PL- Consultation- Conservation Officer response

R/40/26/PL

Address: Mulberry Lodge and Rowan House Cudlow Gardens Sea Lane Rustinton BN16 2RN

The Proposal: Replacement of roof tiles and associated fittings to existing pitched roofs

MULBERRY LODGE

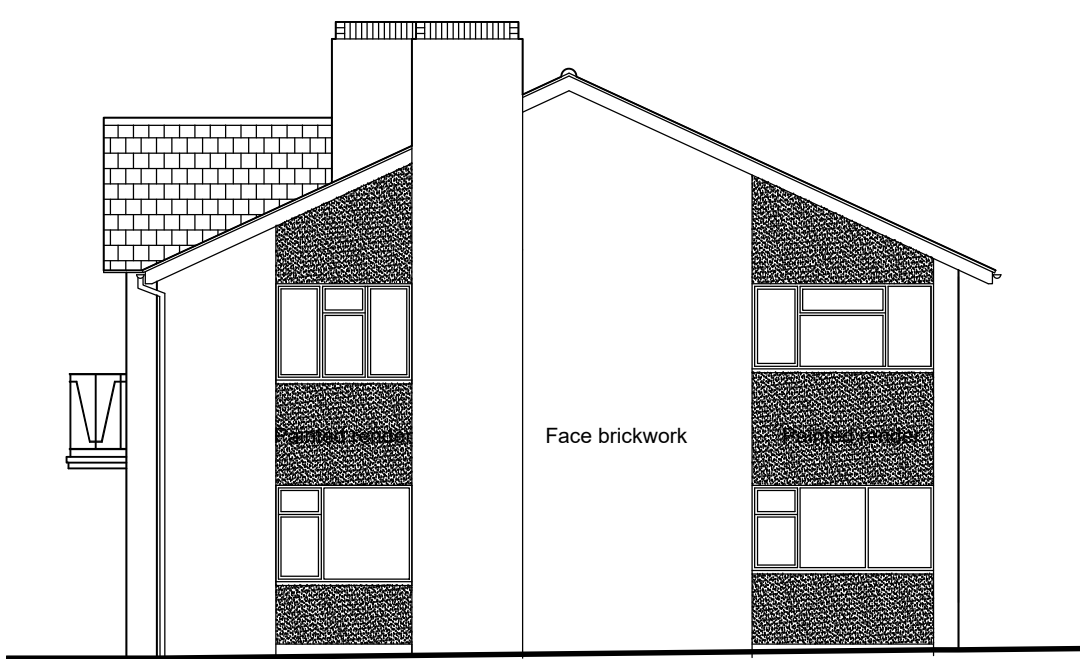
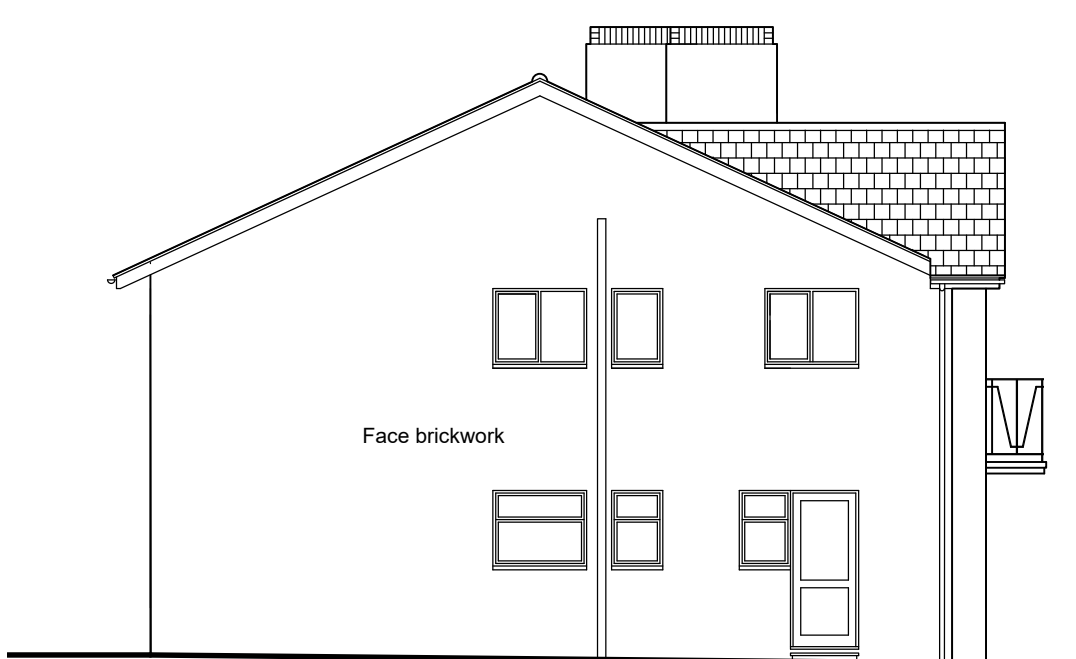
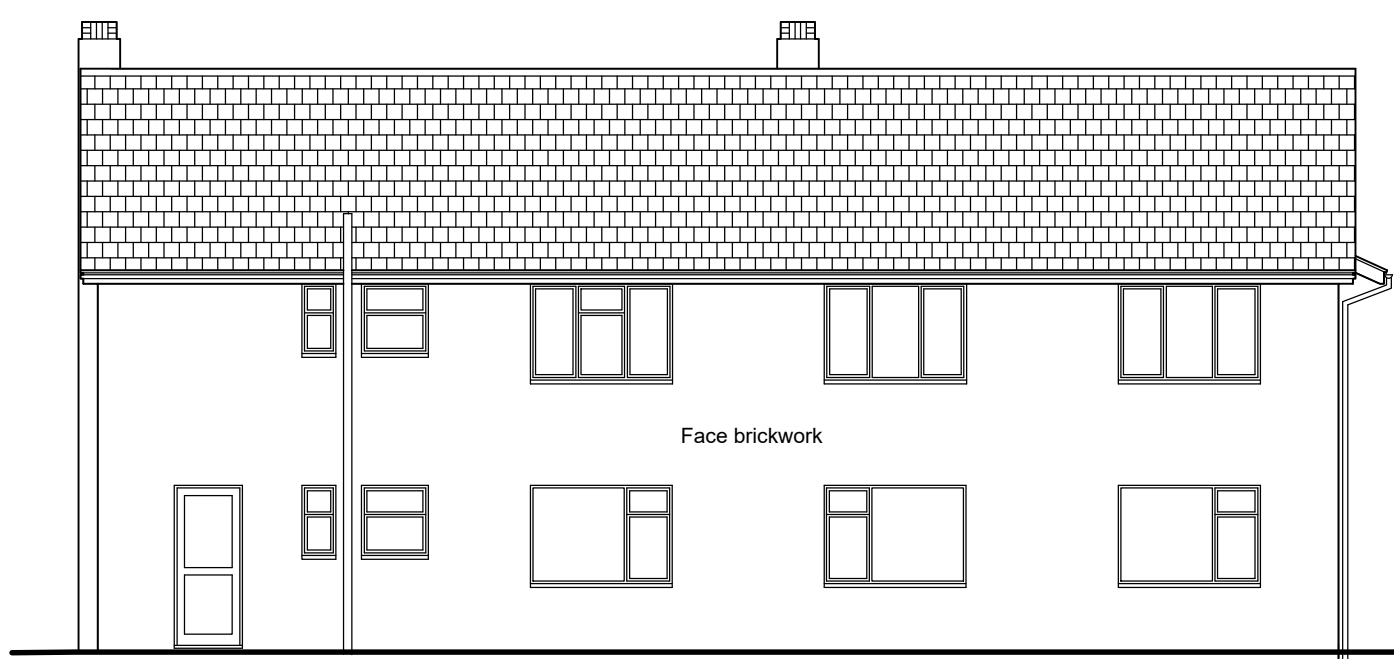
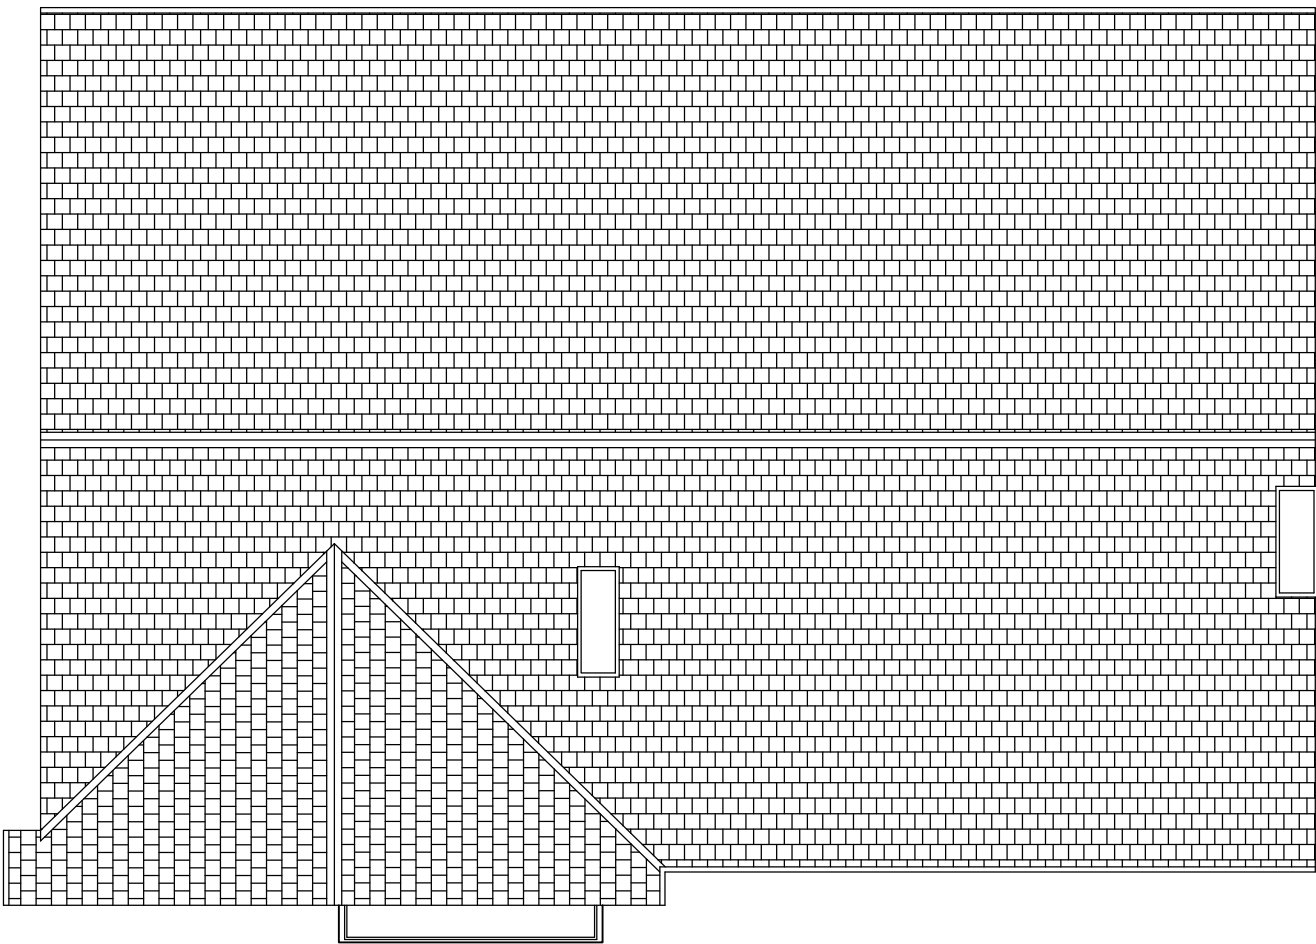
The application identifies that the replacement tiles will be similar to the existing ones and a search online would appear to confirm that similar tiles are available. As a result, I am of the opinion that the impact on the setting of the listed building should be neutral.
